DECISION DELEGATED TO DEVELOPMENT MANAGER

Application No: H13-0130-20 **Applicant:** Mr M Ogunade
Proposal: Front porch extension, garage conversion and creation of rear dormer
Location: 7 Benton Close Moulton Chapel Spalding
Terminal Date: 20th October 2020

Drawing:
 Proposed Plans and Elevations

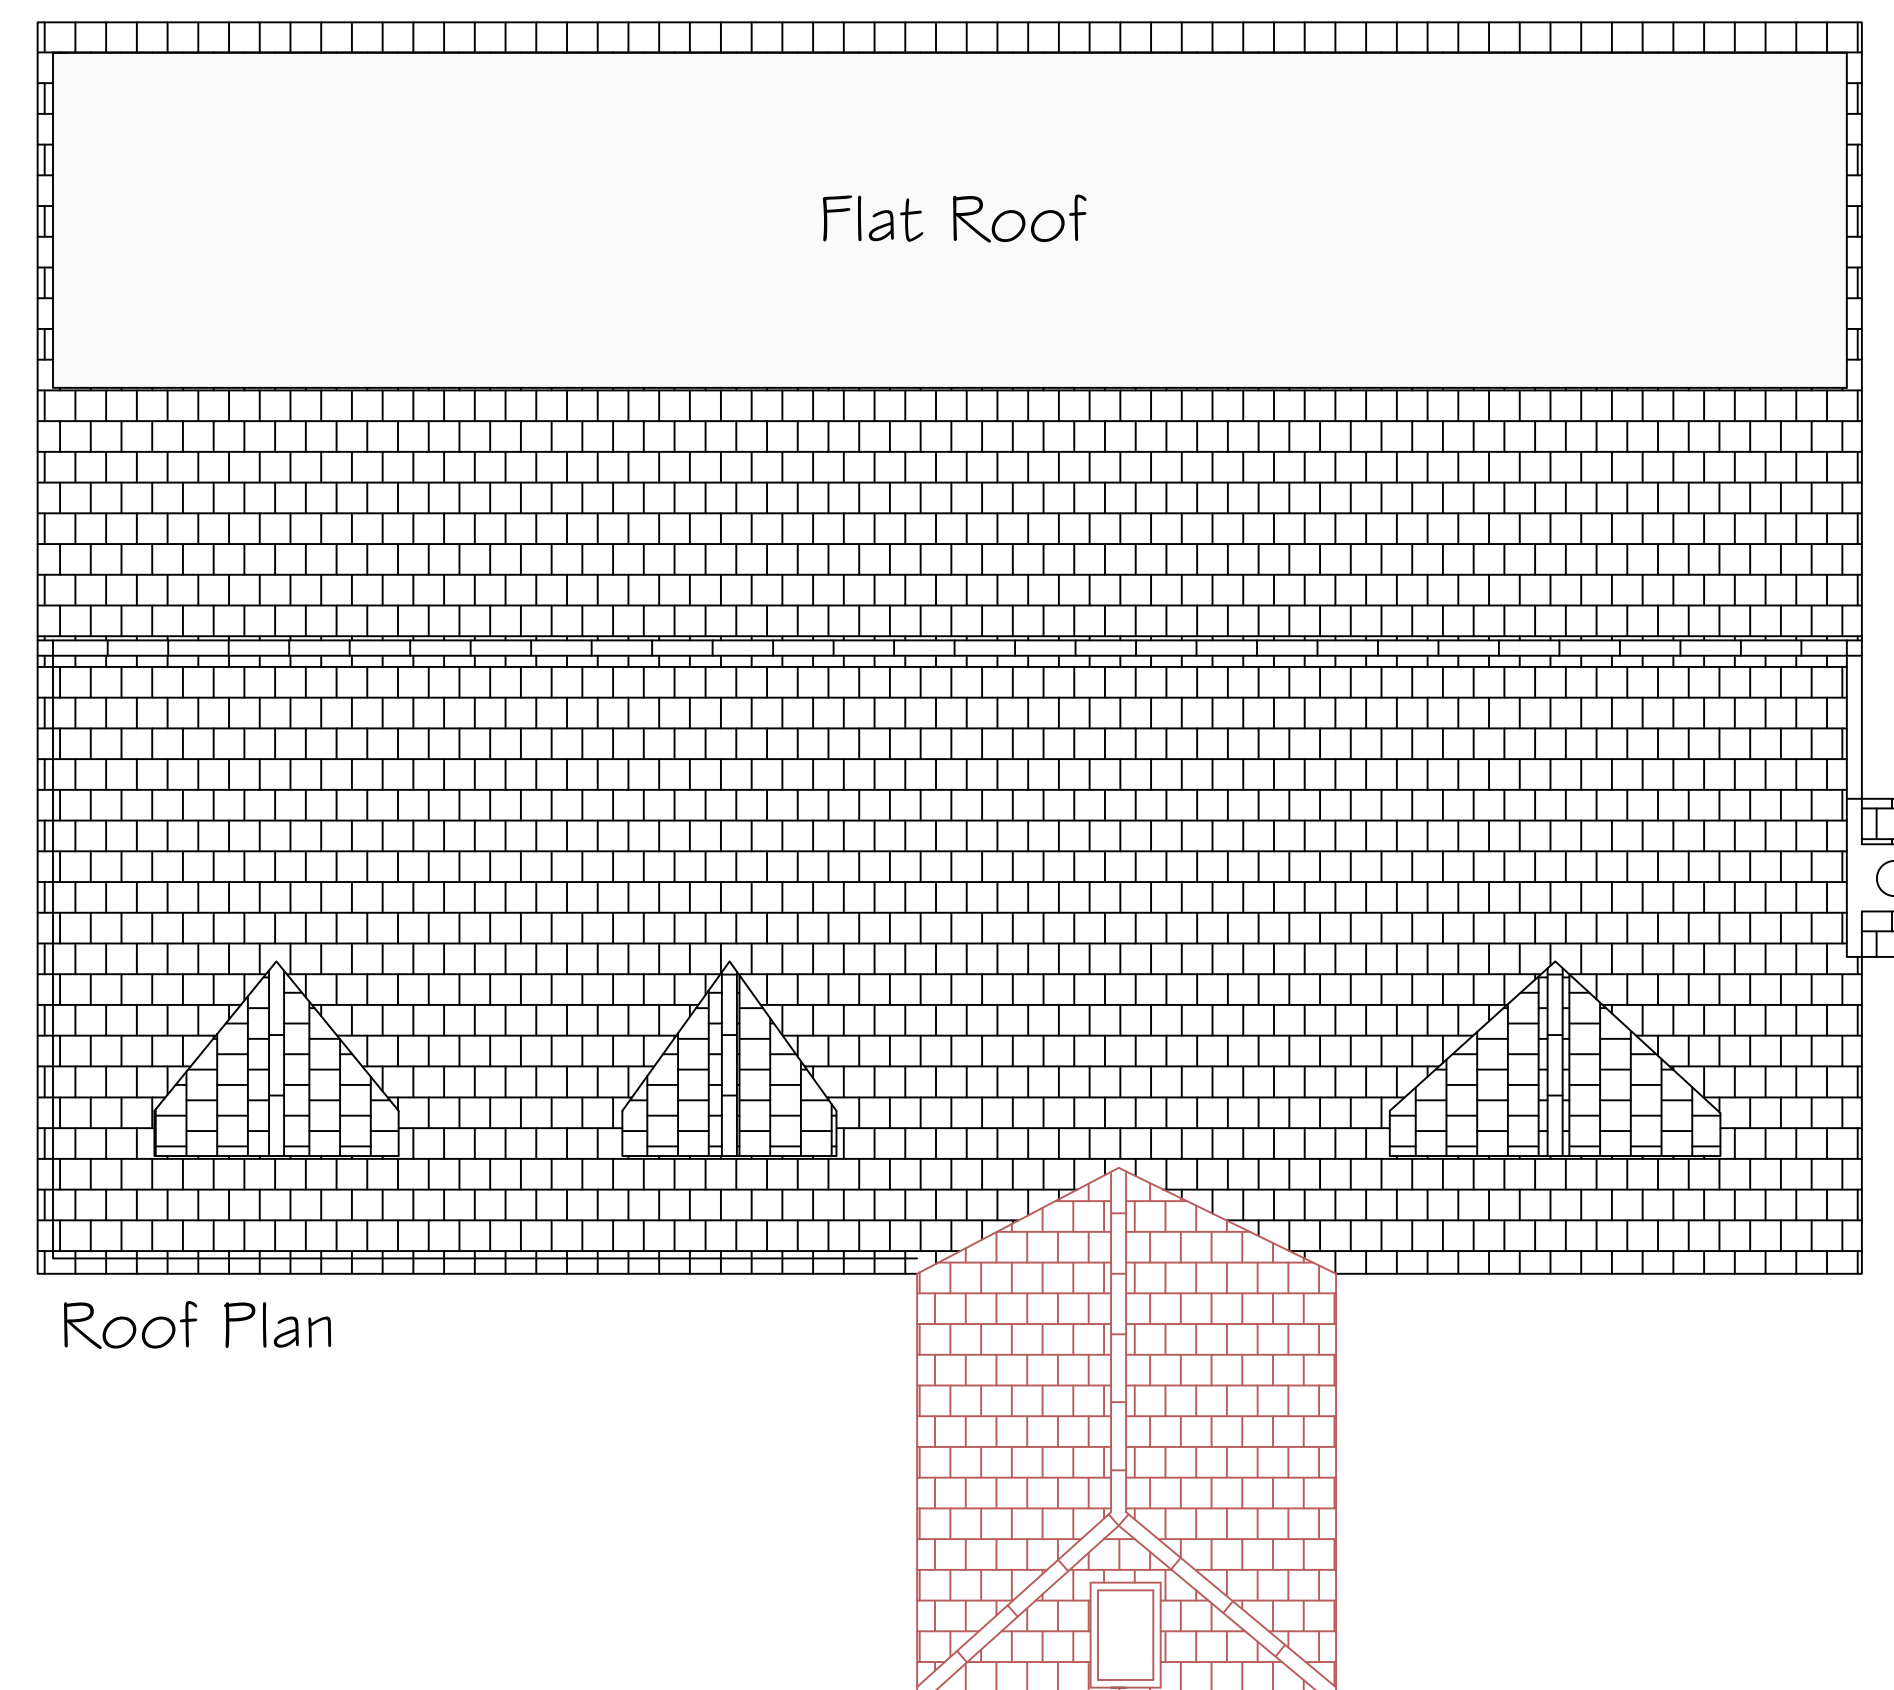
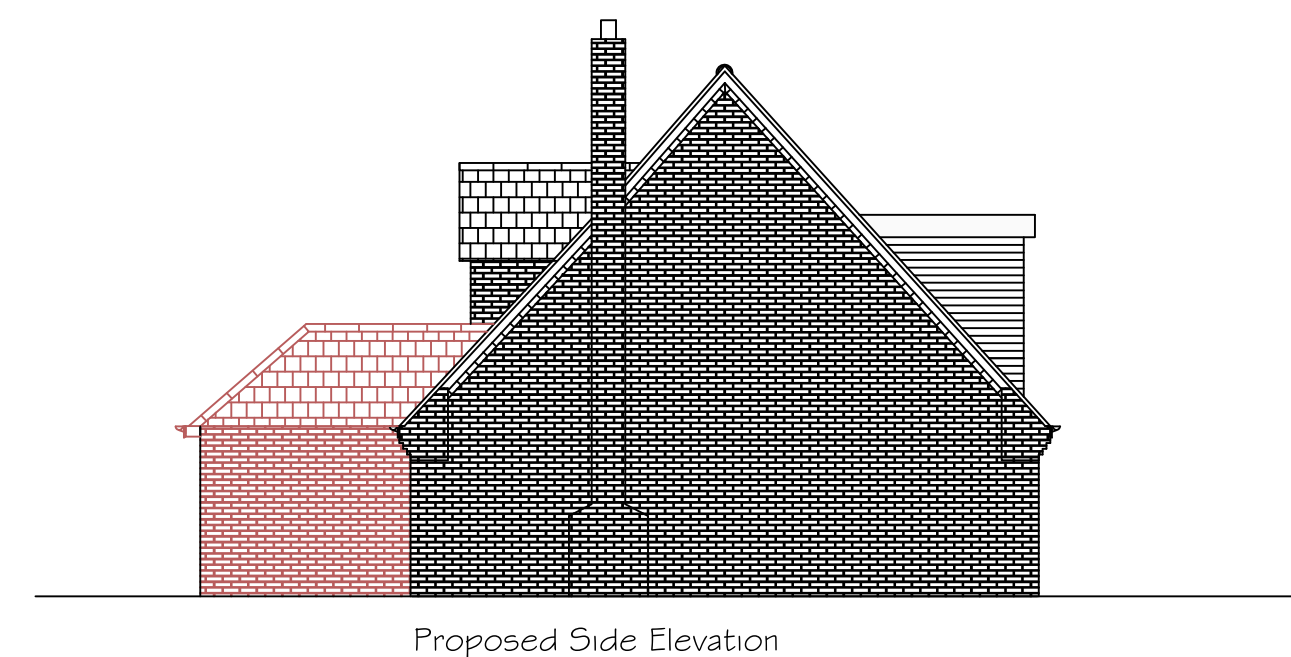
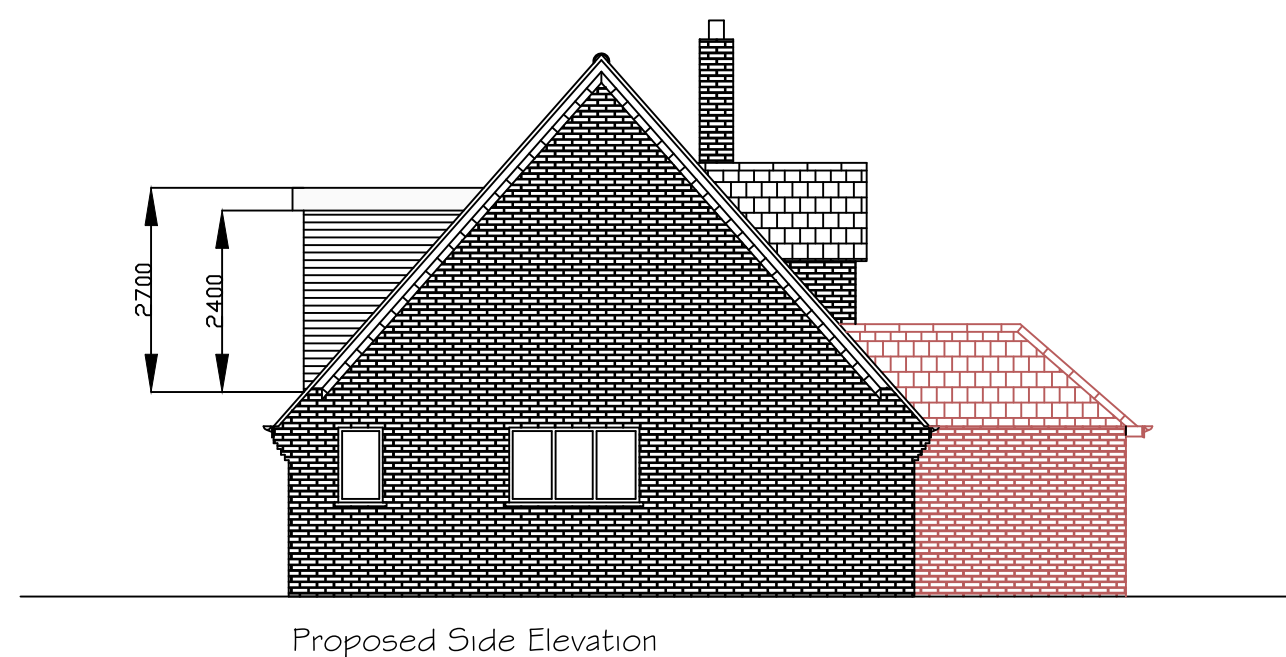
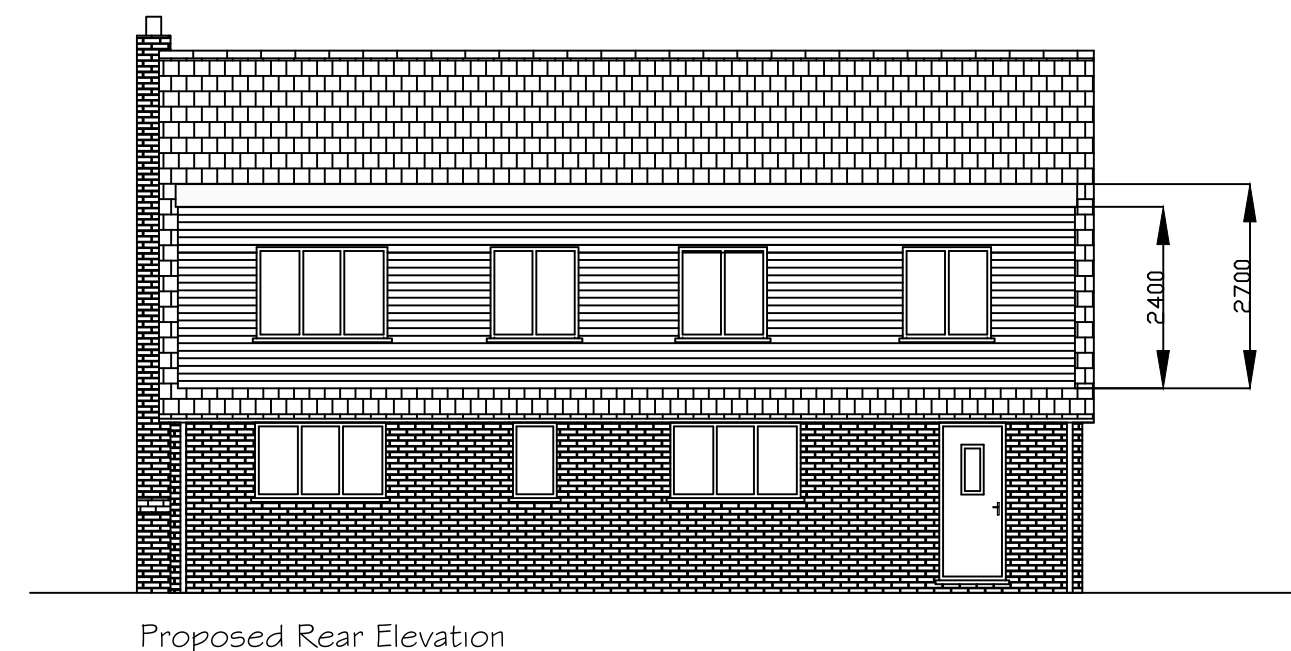
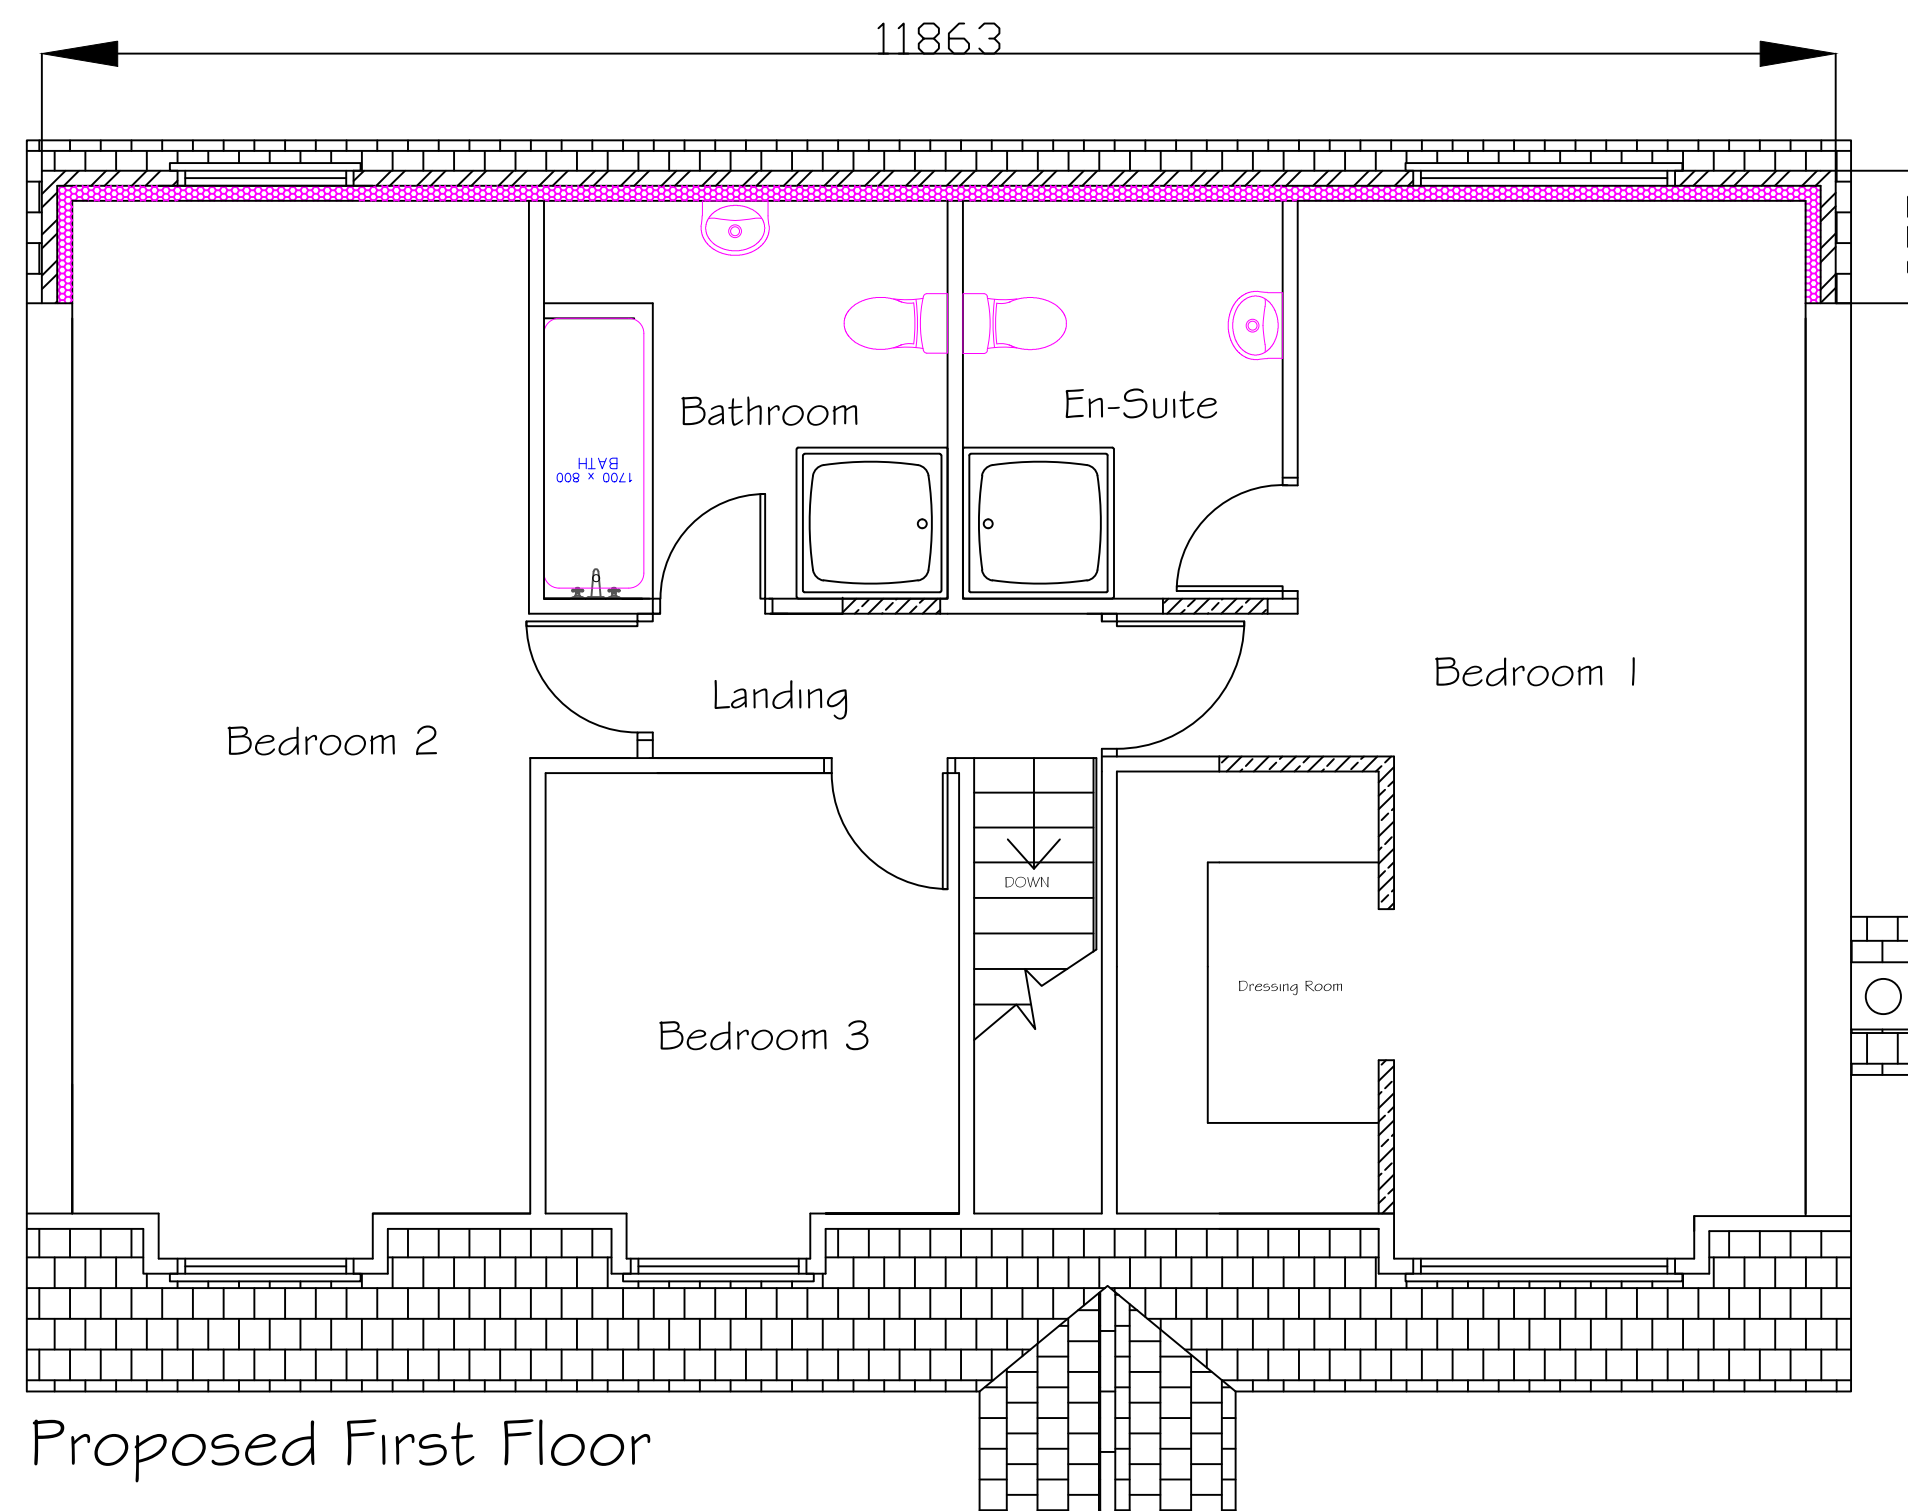
The initial plans proposed a box shaped dormer including four windows. After following discussions

The front porch will be bricked in all external elevations. A hip roof will be on top of the porch which will provide further variety to the mixture of gable pitches on front dormer windows and shed roof on the rear dormer. Formerly, the proposals include a box style rear dormer. The revised plans have replaced the flat roof for a shed roof which will avoid an eyesore and contribute to soften the sharpness of the form of development and, ultimately, deliver a high quality designed loft conversion.

with the agent, revised plans were submitted showing a shed roofed dormer. The number of four windows remains.
